**From:** <Pikefambily@aol.com>  
**To:** <jf@portlandmaine.gov>  
**Date:** 5/22/2014 4:34 AM  
**Subject:** Proposed building at 97 Cumberland Ave, Portland

May 21, 2014

Thank you very much for allowing me to look over plans and sketches today for the proposed construction at 97 Cumberland Ave. I have several serious concerns that I would like to bring up in regard to the proposal.

Preliminary Site Plan

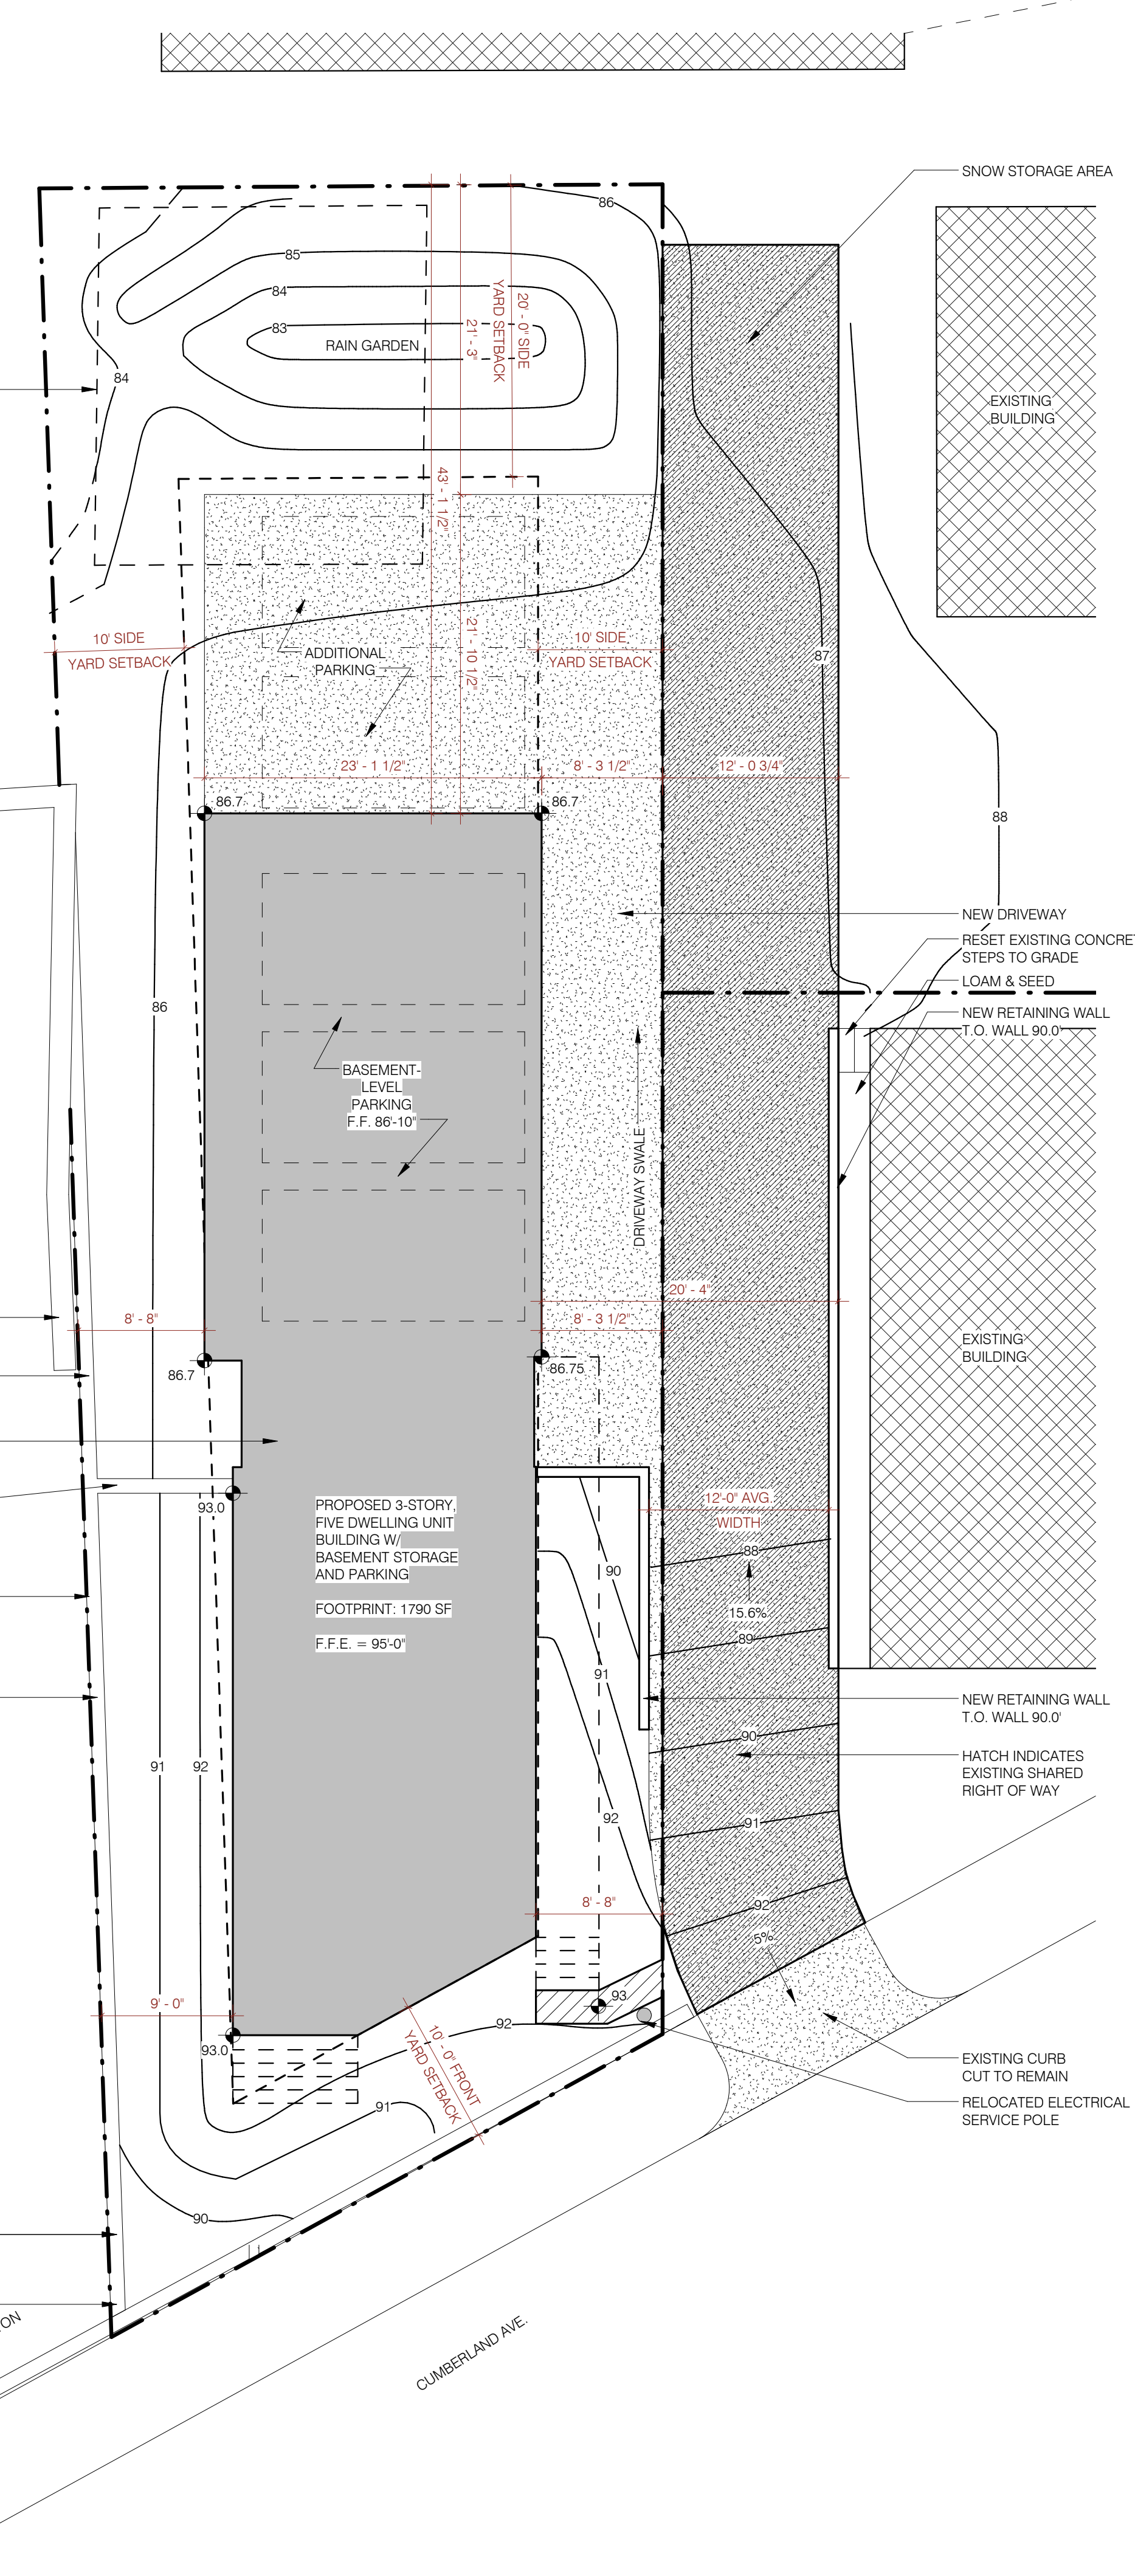
2. In addition to this proposed illegal change of use in the right of way, the submitted plans to create elevation changes to the right of way across my land are of very great concern. My building at 93 Cumberland Avenue

was built into the side of the hill over 100 years ago. The right of way runs along the downhill foundation side of my building. The currently proposed changes include the creation of a new retaining wall in the 14' wide right of way approximately 2 feet away from the foundation of my building and running the entire length of my building. The proposed plan is to raise the site elevation so much that it even requires the architect to call on the plan for alterations to be done to my building, including the "adjustment for downspout (on my building) to drain through new wall to pavement", as well as to "reset (the) existing concrete steps (to my basement) to grade".

This proposal appears to leave me with a 2 foot wide ditch along the foundation of my building, which the plan offers to "loam and seed". The proposed paved width is 12', taking up the entire remainder of the right of way. Snow plowed along this newly paved way would quickly fill the ditch along my foundation and pile snow up against my basement windows, most likely flooding my basement. Rain water runoff from the newly created elevated pavement could easily do the same. My building has basement windows which would now be put partially underground in a gully in this proposal. My basement steps have always run in the upward direction, not the downward direction.

97 Cumberland Ave. - Proposed

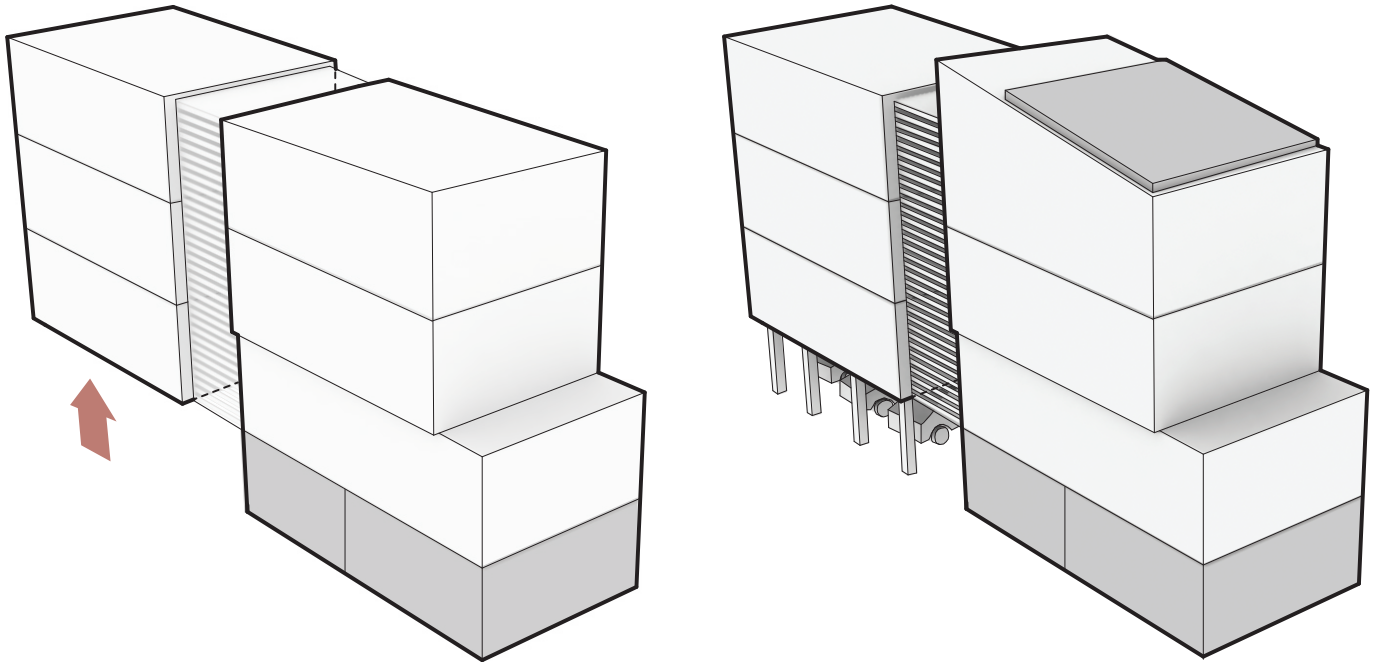
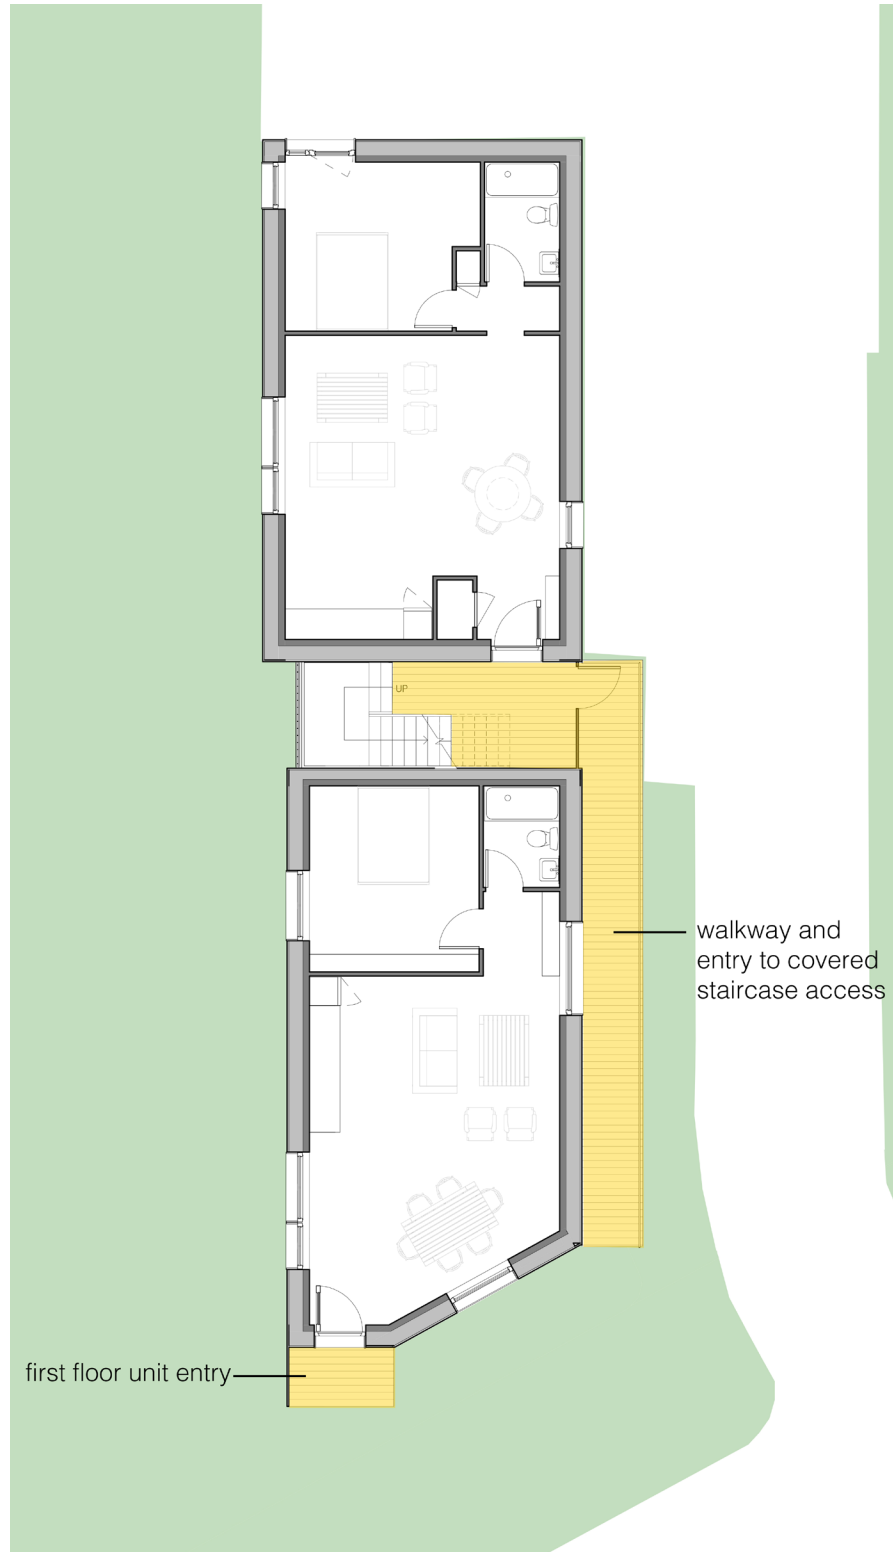
3. On a different note, while my husband James and I applaud the energy efficiency and modern technology choices of the proposed structure at 97 Cumberland Ave., we do not applaud the industrial theme of the structural design. It is disappointing to us to see new construction in one of the oldest neighborhoods in Portland being modeled after renovated factory buildings. Additionally, the renderings of the proposed building show a very solid wall with few windows on the north side which faces our building at 93 Cumberland Ave. The lack of windows combined with the untraditional choice of siding leaves an impression that, in our opinion, is unfriendly, at best. Munjoy Hill has many beautiful old homes that recall the proud historical past of Portland. We own three buildings near 97 Cumberland Ave that we intend to keep as historically correct as possible, paying homage to the history of Portland, Maine. We are sorry to see that this proposal does not honor the history of Munjoy Hill as one of the first residential areas of our beautiful city.
